Rezoning Transportation Analysis

Petition Number: 2020-088

General Location Identifier: Tax ID 02932106A

Date	Description
07-23-2020	First Review

OPTION 1A: PROSPERITY RIDGE ROAD EXTENSION SECTION WITH BICYCLE LANES (SHOWN WITH ON STREET PARKING WHERE APPLICABLE)

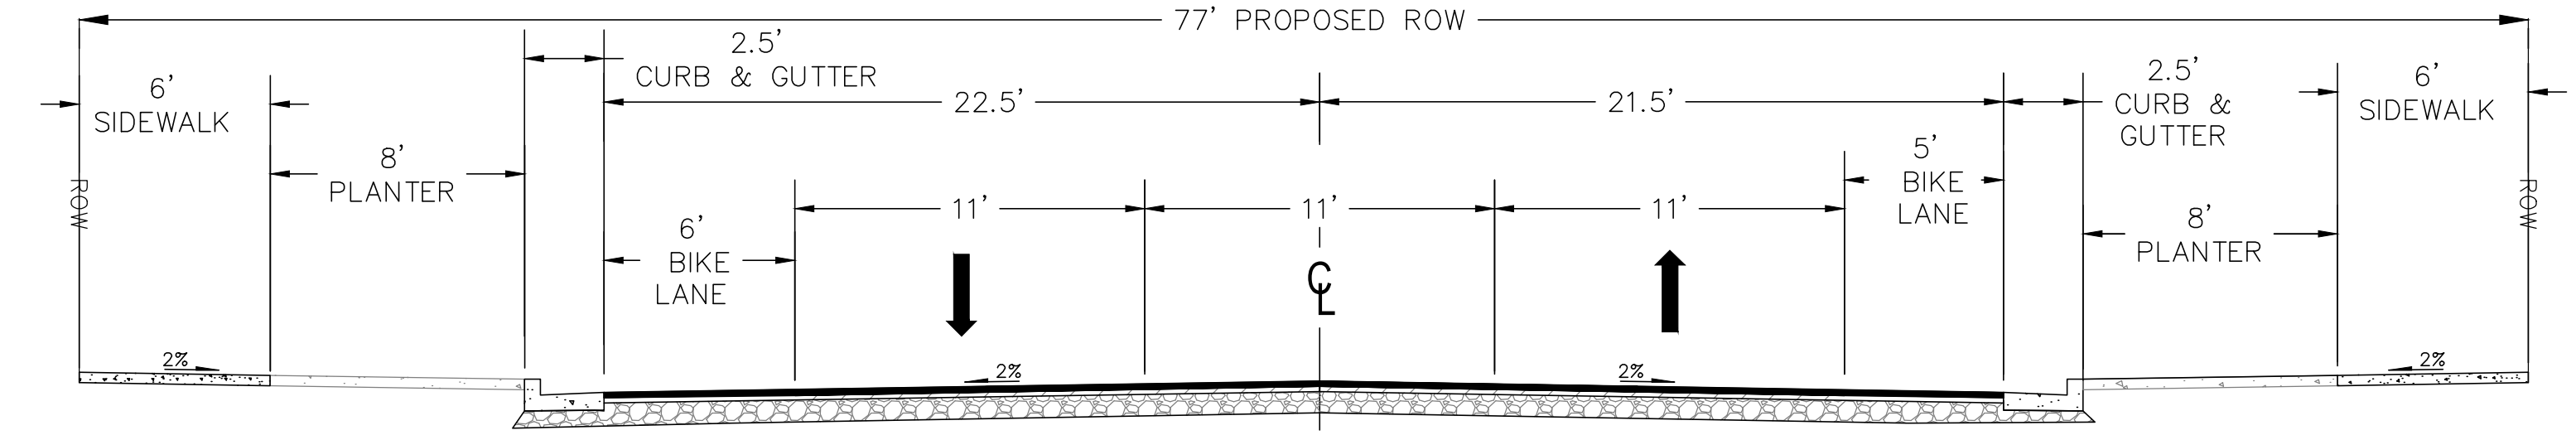
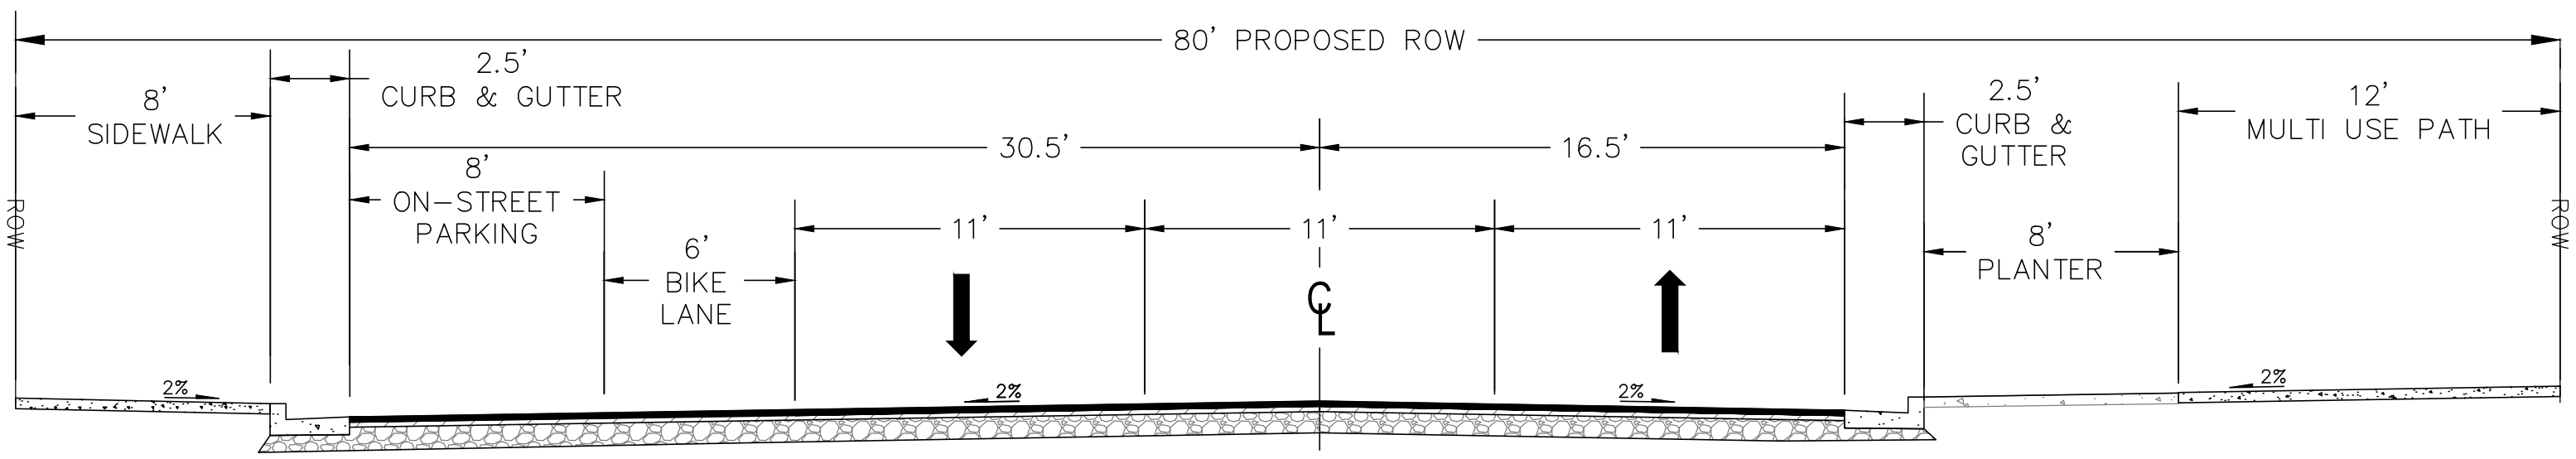
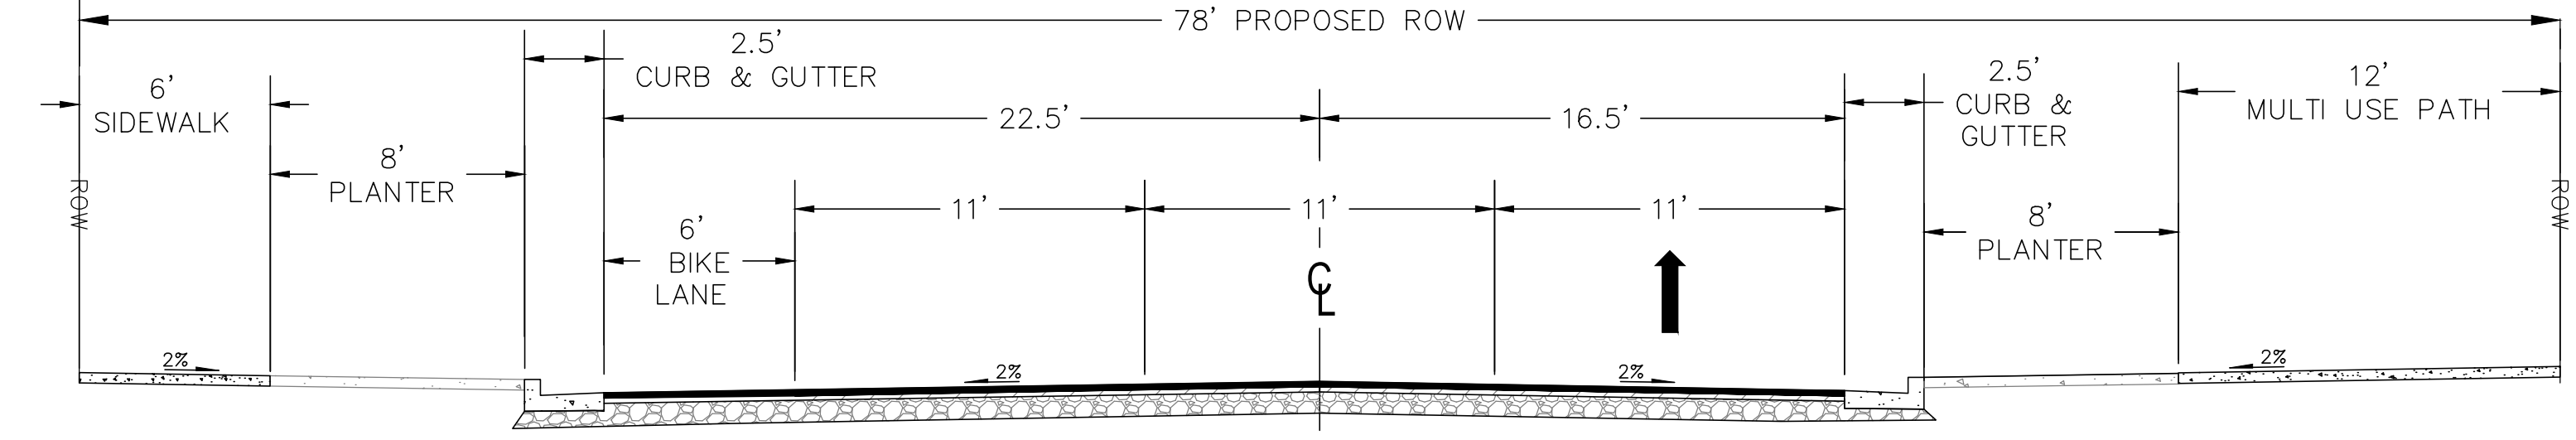
7. The petitioner should revise the site plan and conditional note(s) to revise the Prosperity Ride Road Extension to replace the proposed 4-foot bike lane with a 5-foot bike lane. Please revise the proposed valley gutter shown to a 2.5-foot curb and gutter.

PCR MIXED USE
 PREPARED FOR
WSB RETAIL
 CITY OF CHARLOTTE, NC
 SHEET NUMBER
RZ-1

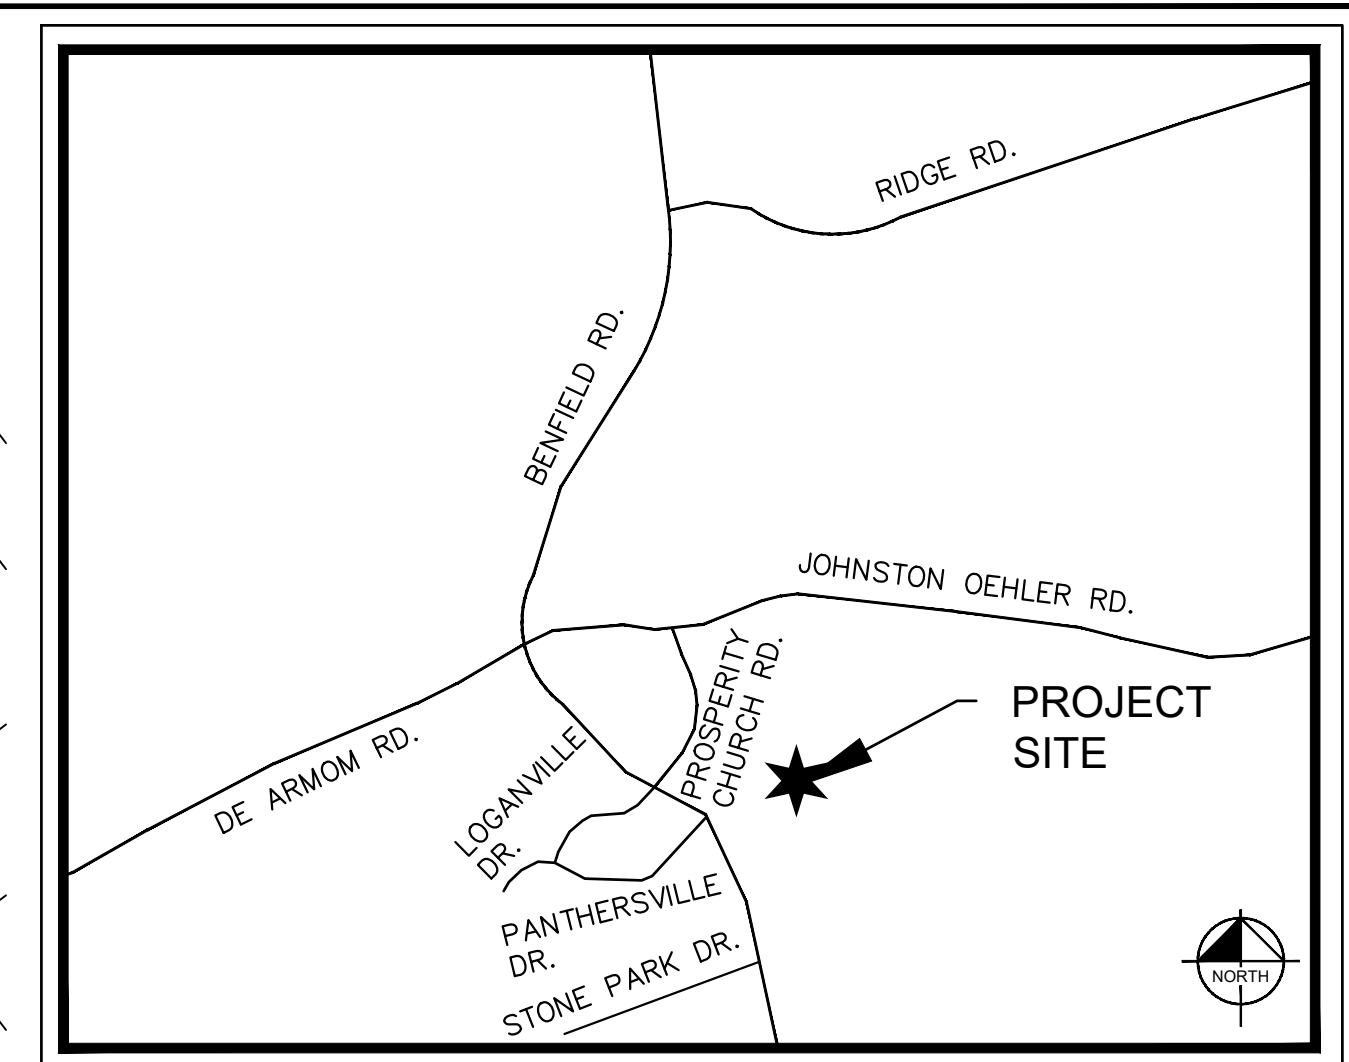
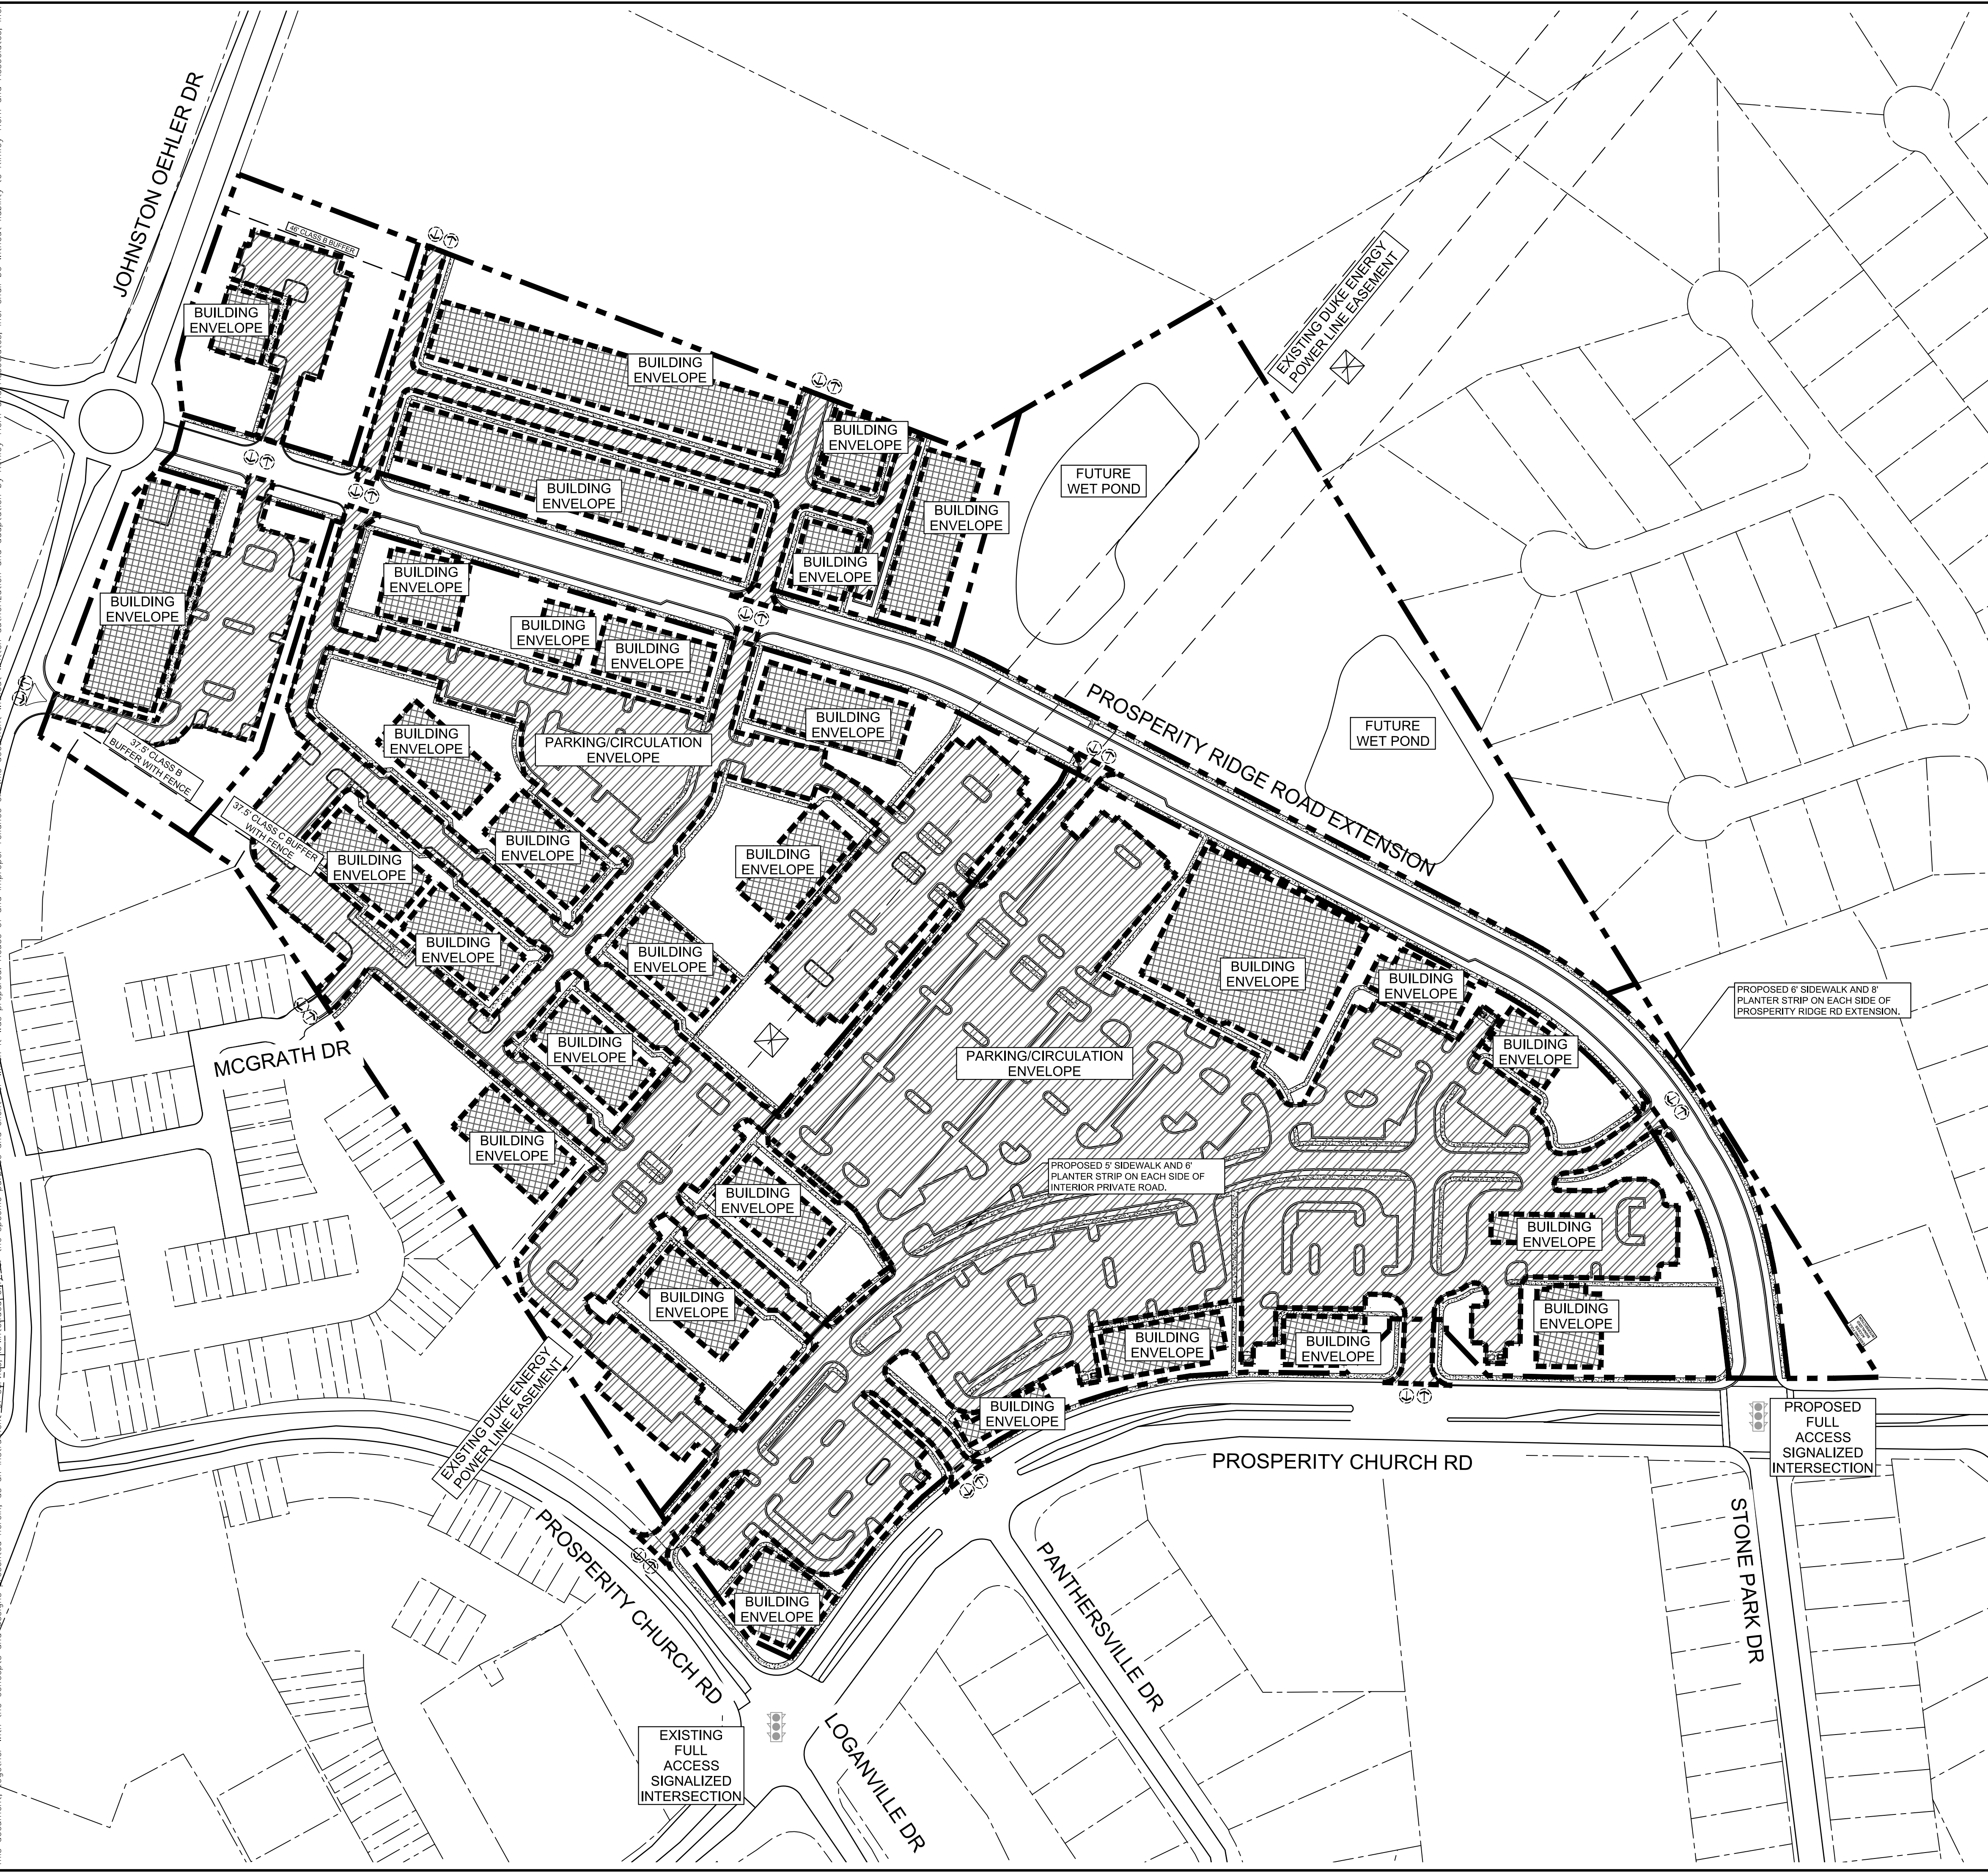
1. **Curbline** The proposed zoning district has a setback measured from back of the existing or proposed future curblines.
 - a. **Johnston Oehler Drive:** Location of curb and gutter should be placed per A5 below.
 - b. **Prosperity Church Road:** Location of curb and gutter should be placed per A1 below.

The site plan should show the curb and gutter labeled and dimensioned from the centerline for each road.

3. In accordance with the Prosperity Hucks Area Plan road cross sections, the petitioner should revise the site plan and conditional note(s) to commit to dedicate right-of-way from the Johnston Oehler Drive and Prosperity Church Road centerline. The site plan should label and dimension the right-of-way from the road centerline. Please provide 2 feet of right of way from back of sidewalk where feasible.
